Design Statement Addendum

200-202 Panfield Lane

Proposed Demolition and replacement of 200-202 Panfield Lane

August 2020

Proposed Demolition and replacement  
of 200-202 Panfield Lane  
Plot 1 Proposed Floor & Roof Plans

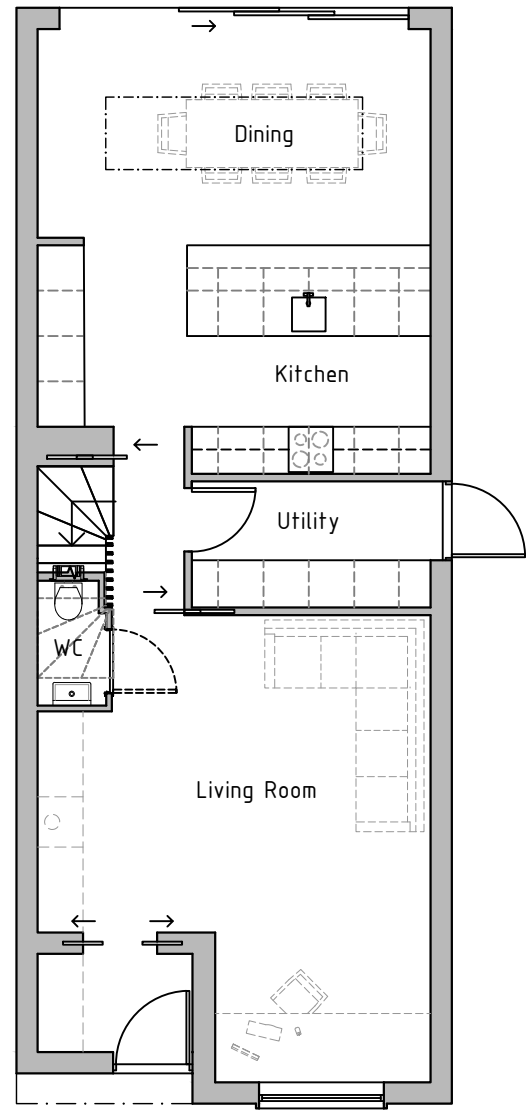
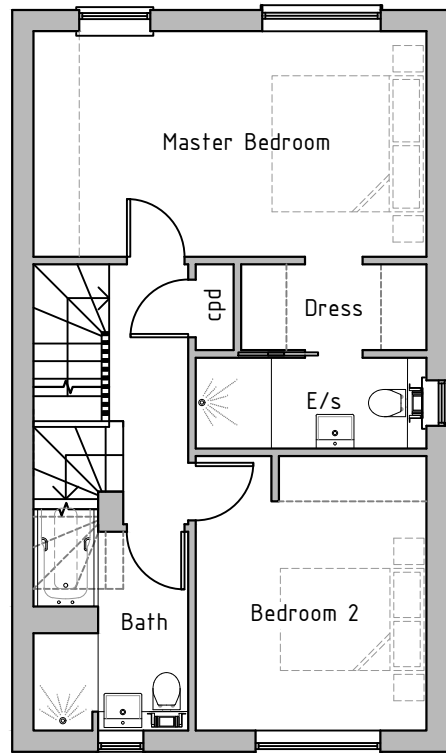
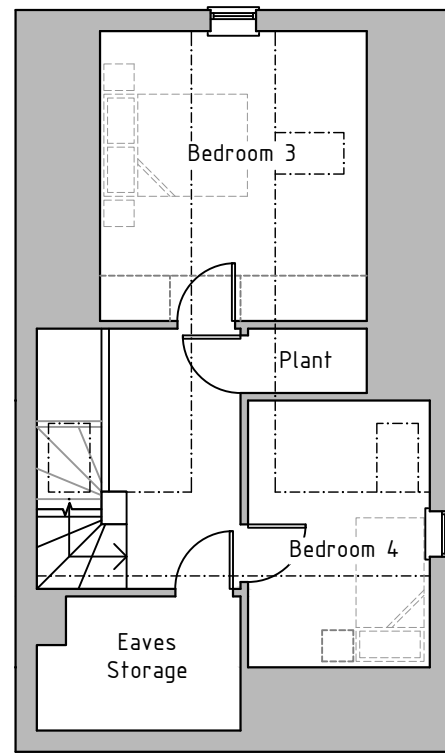
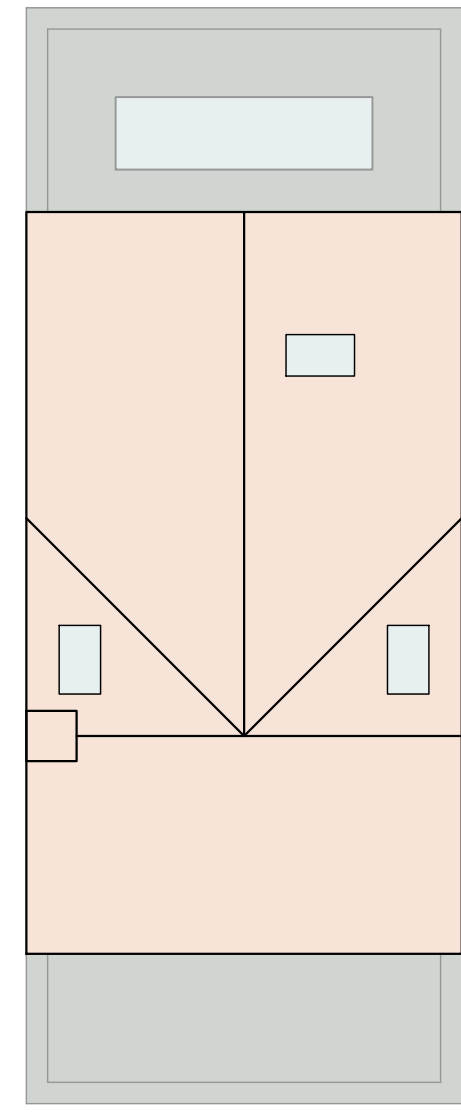
4. The resulting buildings would be bulky, appear to be cramped and at odds from the street scene;
5. The depth of the proposed dwellings are more than double of the original dwelling and those of the neighbours;

6. The 2-storey rear elements are not in line with the building line of the neighbouring properties and would appear overbearing as compared to the rear building immediate neighbouring properties, which would be highly visible from the public realm, in particular from Pegasus Way.

The green line demonstrates an indicative building line which the new dwellings could be designed to fall in-line with. The dimensions shown on the drawing demonstrate that the first floor elements (as proposed) would extend beyond this building line by 3.0 metres on Plot One and 3.5 metres on Plot Two.

If the scheme was designed to line through with the rear walls of the adjacent properties, first floor rear extensions to a depth of **3.0 metres** could be carried out at a later by the occupants of the dwellings without formal planning consent. Whilst we recognize the LPA cannot control GPDO extensions, they should recognize that these works would be considered acceptable under national planning policy under the criteria of the GPDO. This design seeks to achieve a forward thinking design to achieve the most sustainable level of accommodation right from the outset to avoid incongruous development in the future.

Whilst Plot One would be outside the PD rights for two storey rear extensions as it measures 3.5 metres in depth beyond the 'indicative rear wall line' instead of 3.0 metres, the depth would still not cross a 45 degree 'right to light' line so under normal conditions this would likely be accepted by the LPA if it was an application for an extension.

This application could be approved with a condition that removes the permitted development rights from the dwellings in the future to prevent over development of the site thereafter.

Proposed Demolition and replacement of 200-202 Panfield Lane  
Proposed Street Elevation

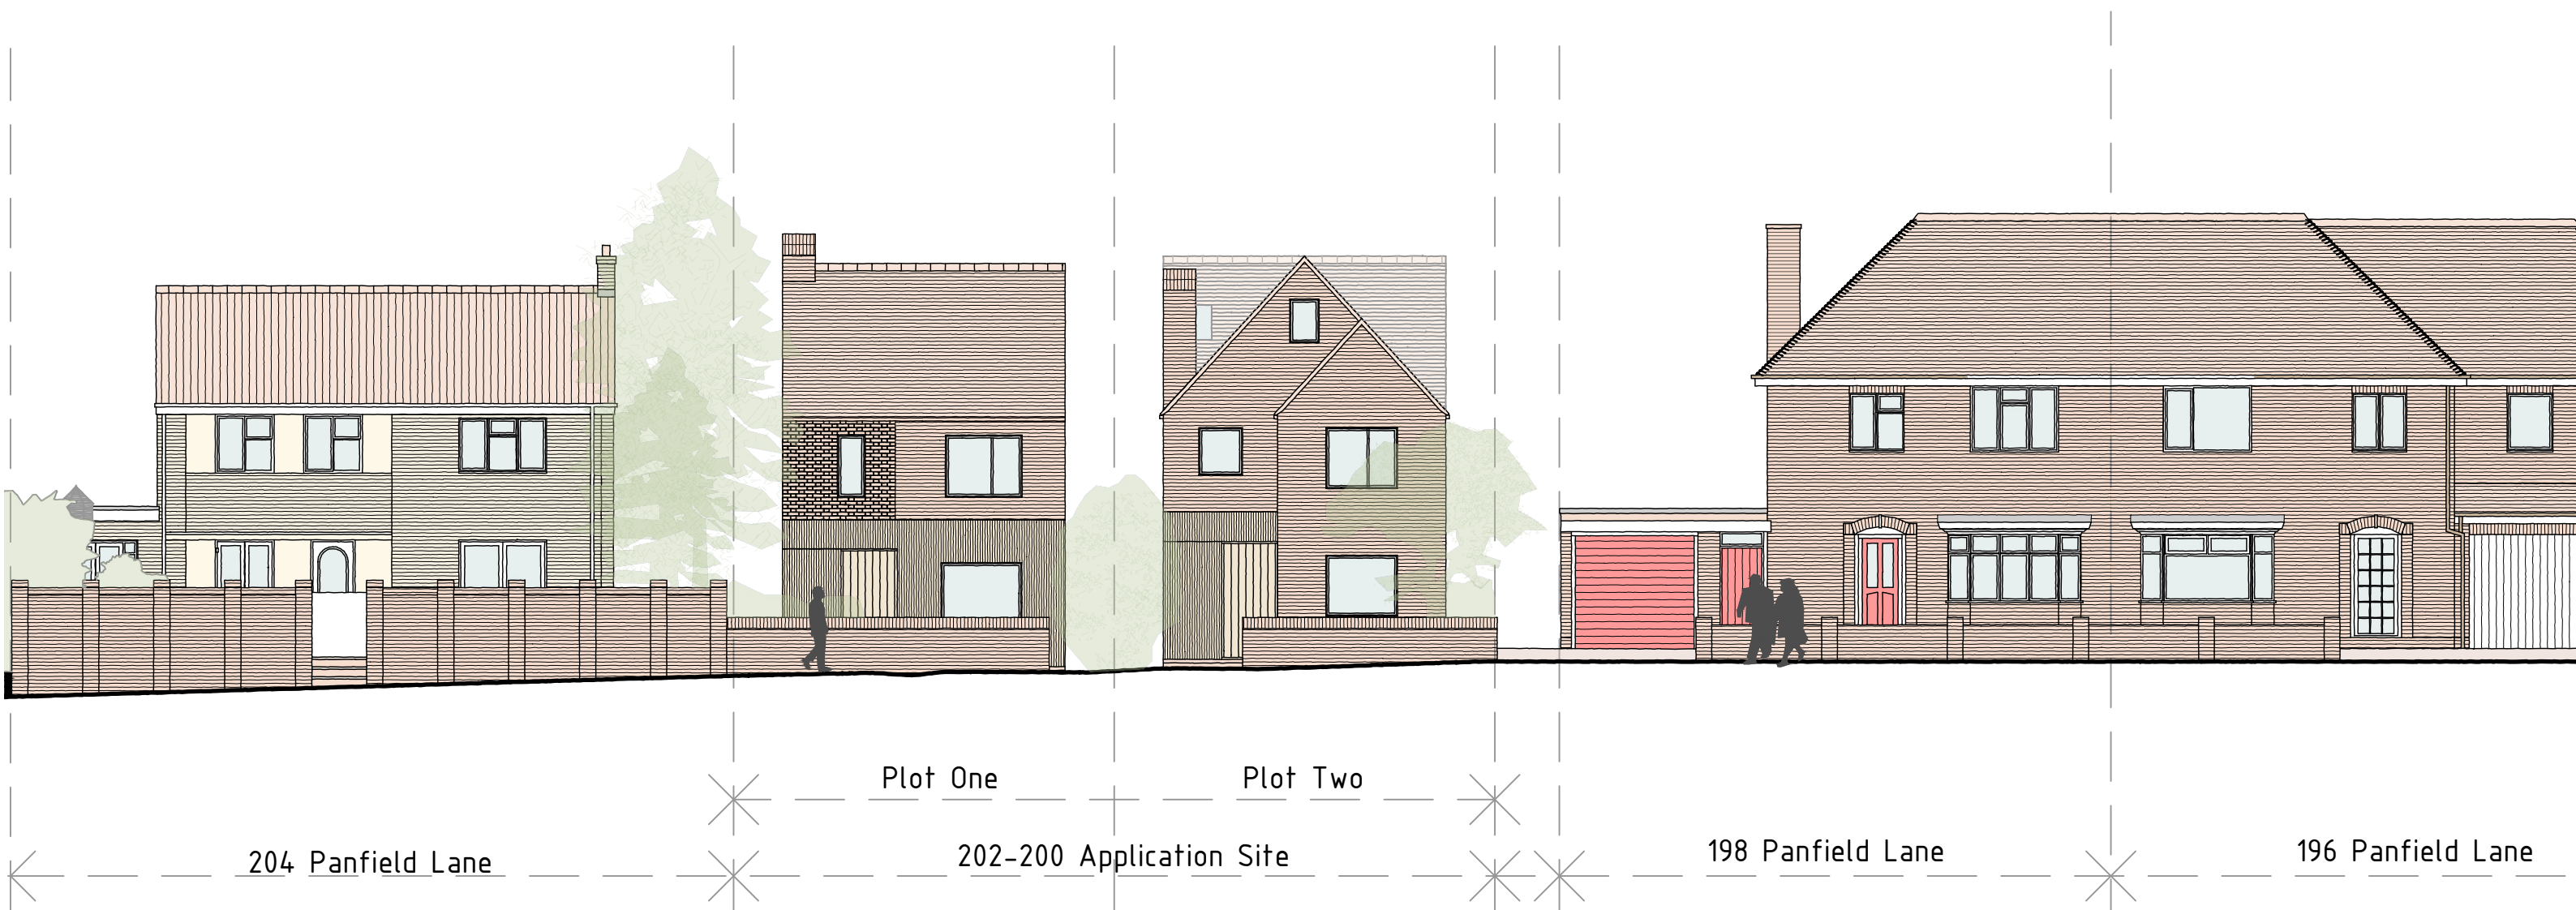
2. The proposed plot width is significantly narrower than the immediate neighbouring properties;
3. The narrow separation distances of the buildings, in particular between the 2 sub-divided plots and that between plot two and No. 204 Panfield Lane, distract from the existing openness of the street scene;

The diagram above demonstrates the proposed ridge and eaves heights compared to the adjacent dwellings. The scale maintains that of the existing, keeping the eaves height the same as 204 Panfield lane and a ridge height that graduates towards the higher ridge level of 198 Panfield Lane. 198 Panfield lane is 1.47 metres higher than 204 Panfield lane and the existing ridge height of 200-202 Panfield lane.

The second image demonstrates the massing of the proposed development where the scheme provides and enhances the openness of the site by introducing separation from the boundaries on both sides and between the two residential units. The single storey and gable features add visual interest and relate to other properties in the wider context.
